Application Ref:	3/2025/0199			 Ribble Valley Borough Council <hr/> www.ribblevalley.gov.uk
Date Inspected:	01/05/25	Site Notice:	01/05/25	
Officer:	LW			
DELEGATED ITEM FILE REPORT:				APPROVAL

Development Description:	Proposed change of use of temporary holiday let back to annex accommodation, conversion of garage to habitable space and fenestration alterations to existing detached garage/ annex building.
Site Address/Location:	Bridgeway, 16 Brookes Lane, Whalley, BB7 9RG.

3 PROPOSED EAST
1 : 50

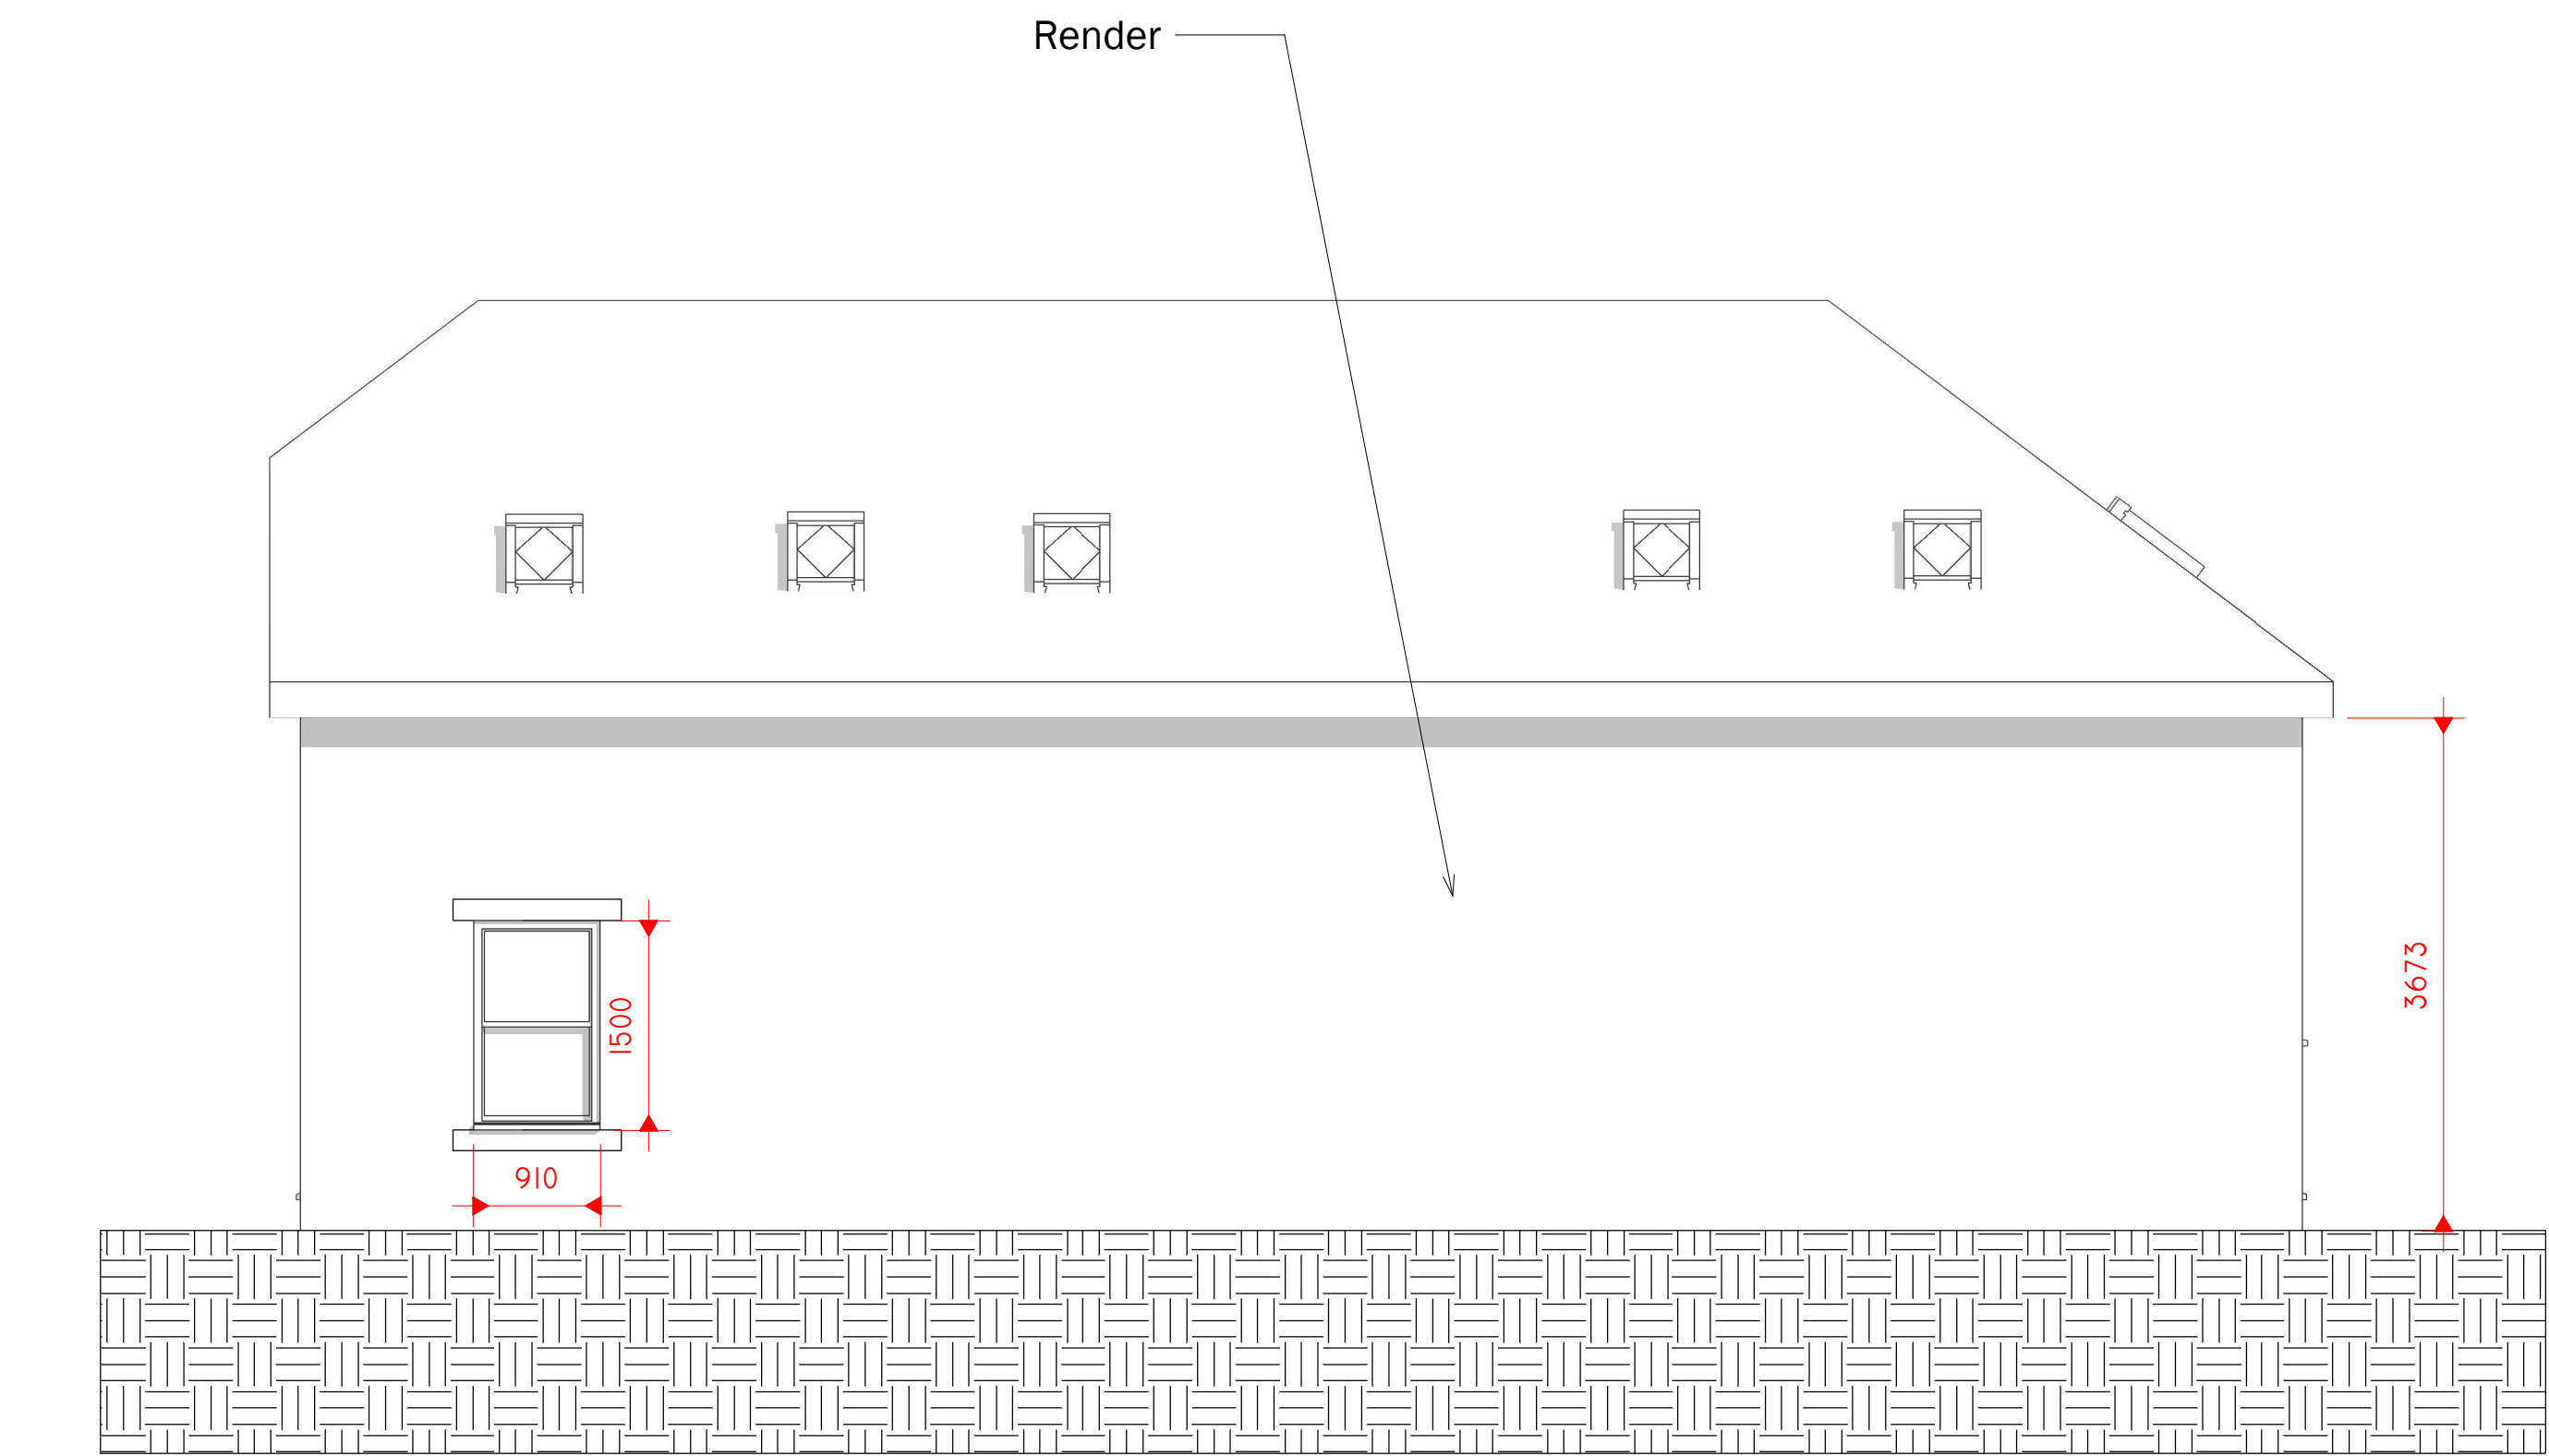
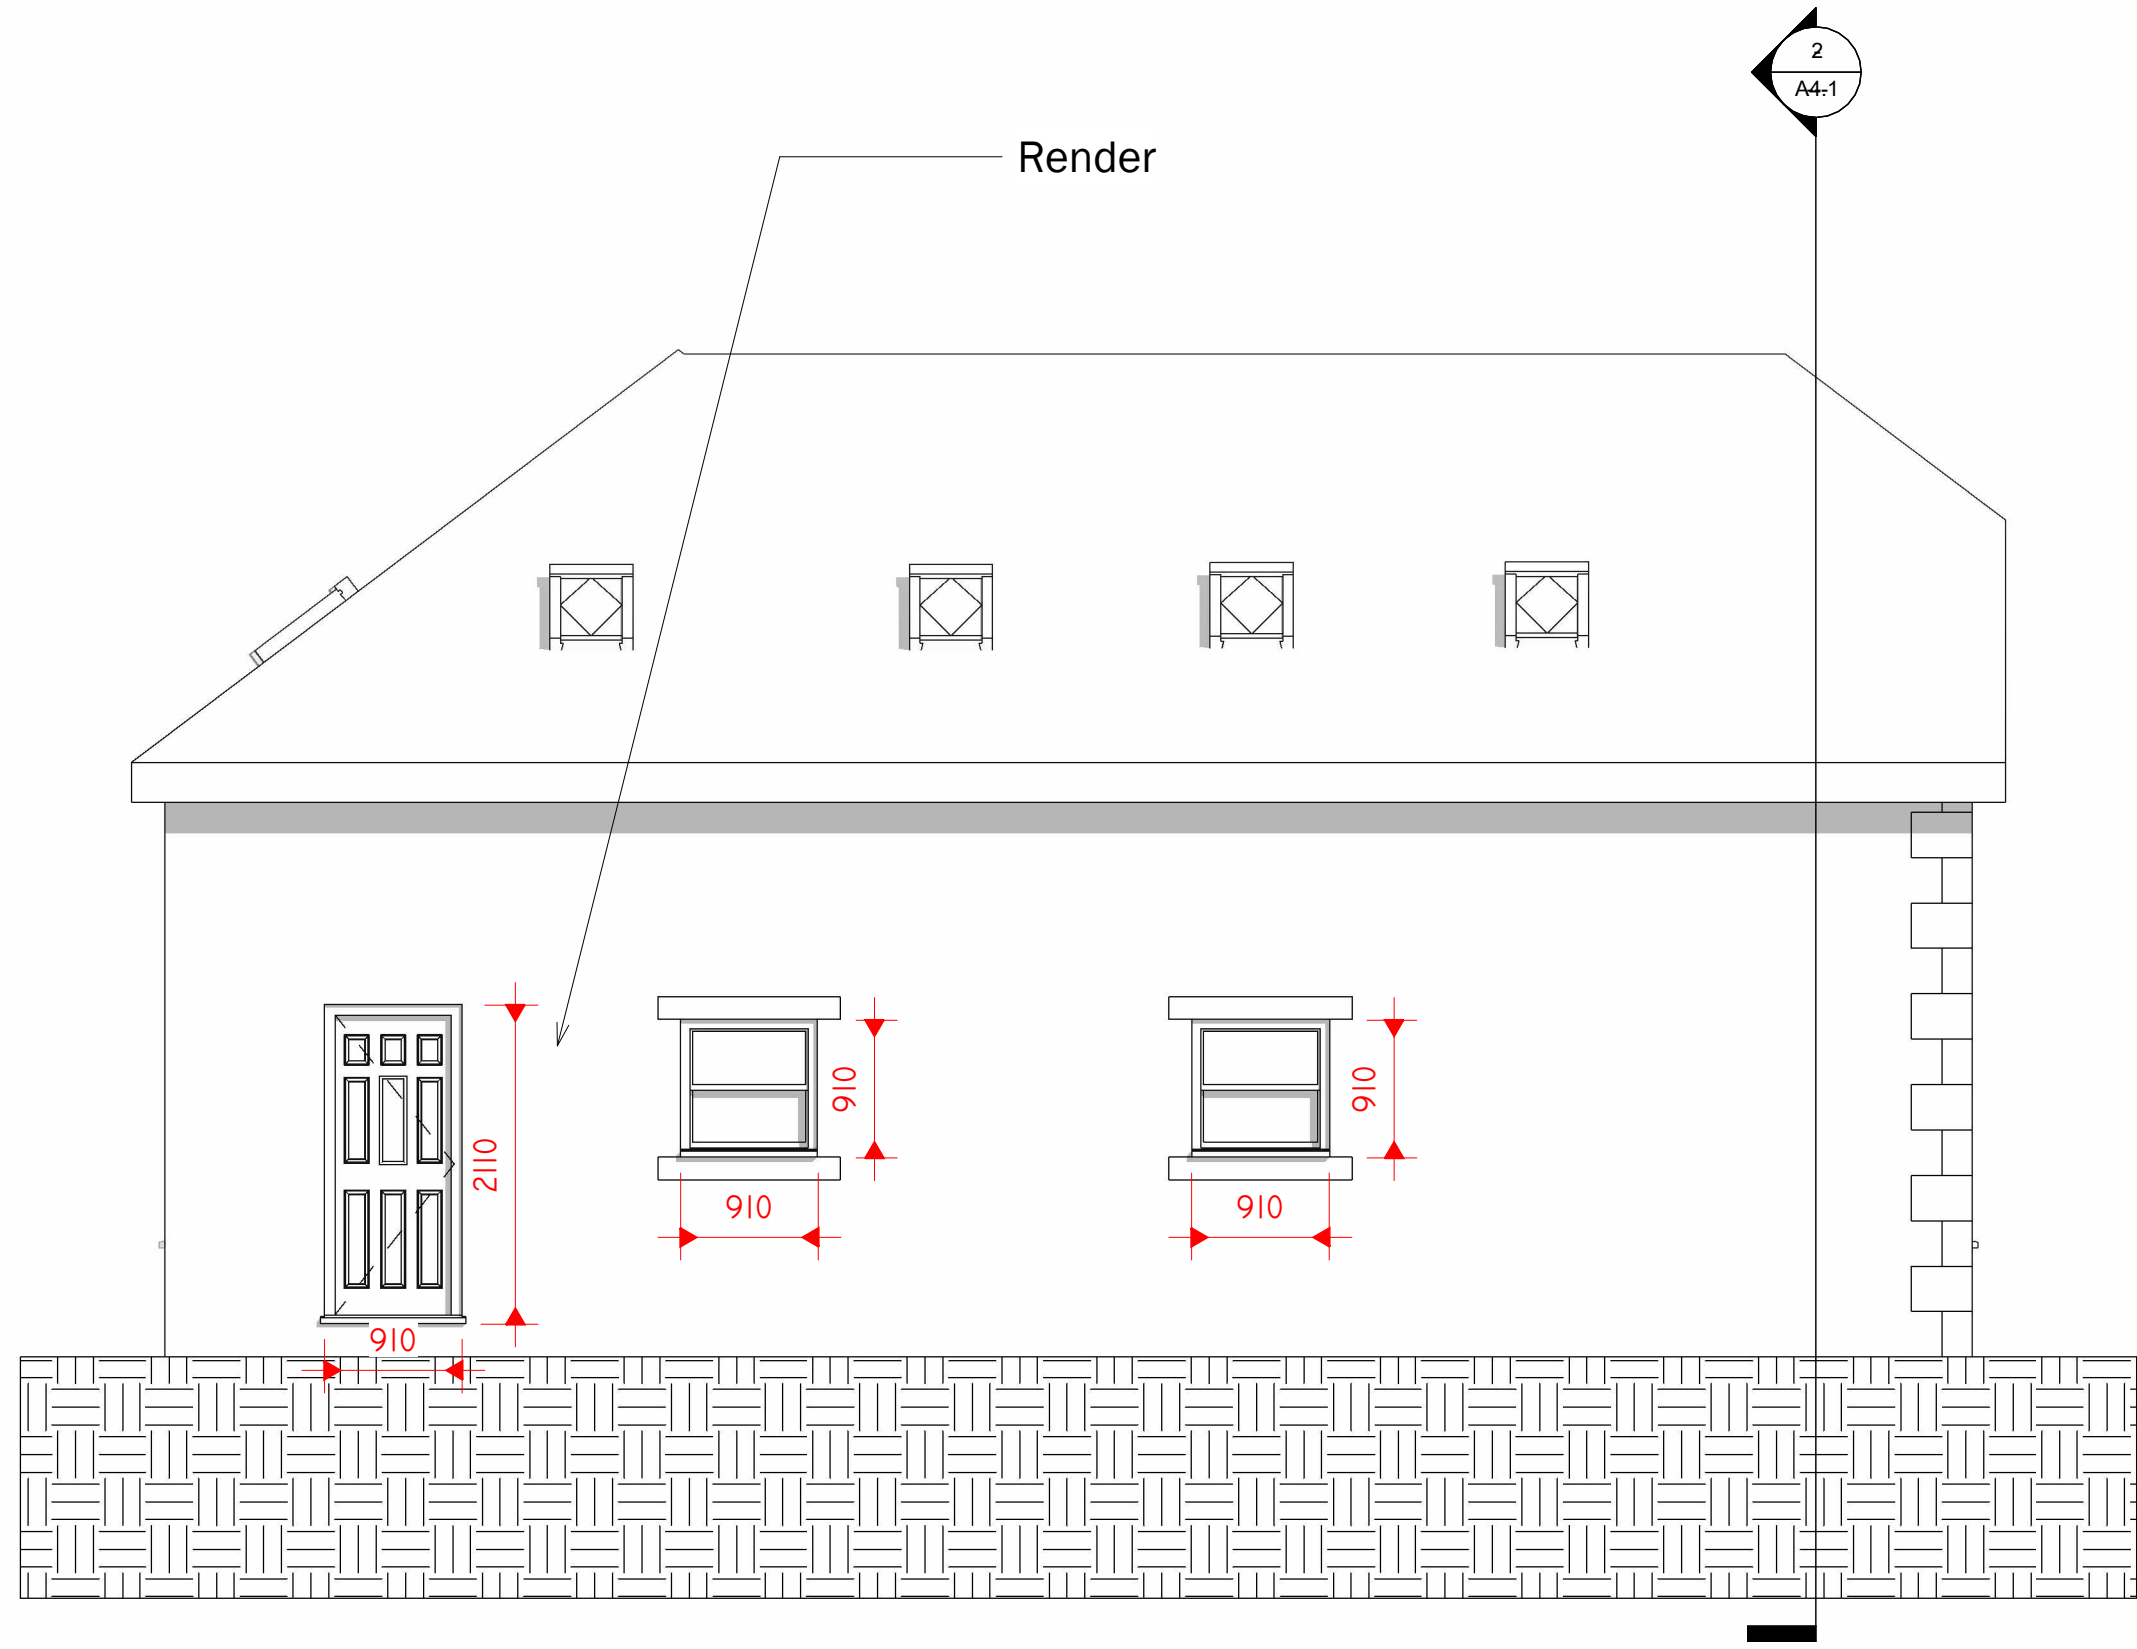
Consent is sought for the change of use of the temporary holiday let back to annex accommodation, conversion of the existing garage into a habitable space and fenestration alterations to the existing garage/ annex building, including the replacement of the existing garage door with 1no. window opening. The proposal has been amended since initial submission following concerns raised by the Officer.

Following discussions with the Agent, the proposed works have been reduced, with the proposed roof alterations, front porch and bay window all removed from the scheme. The number of new openings to

the building has also been reduced. The amended scheme would comprise relatively modest fenestration alterations to the existing built form of the detached outbuilding and therefore it not considered the proposal would result in any significant adverse harm upon the existing visual amenities of the surrounding landscape or the setting of the designated Whalley Conservation Area that would warrant the refusal to grant planning permission in this particular instance. The amendments are therefore considered sufficient to address the aforementioned concerns, with the revised scheme deemed acceptable.

PROPOSED ELEVATIONS

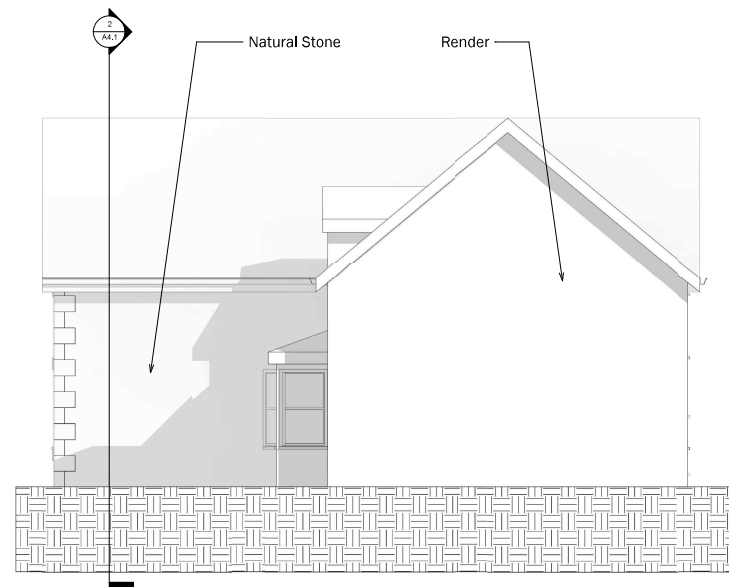
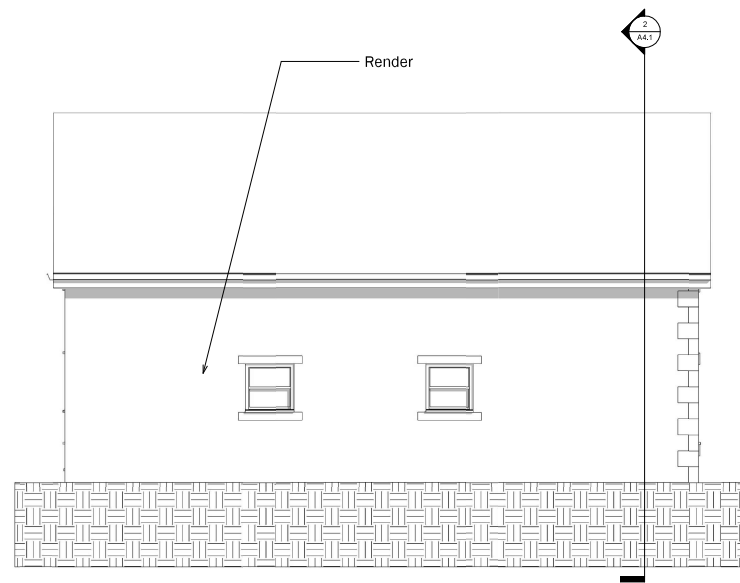
The original scheme proposed a raising of the ridge height and incorporation of a new peak roof to the rear (eastern) elevation, construction of a new front porch and bay window and fenestration alterations including the replacement of the garage door with a new window opening and addition of 6no. windows to the rear elevation. The cumulative impact of these alterations was considered to result in the building no longer reading as a subservient outbuilding, instead appearing more akin to a separate residential dwellinghouse.
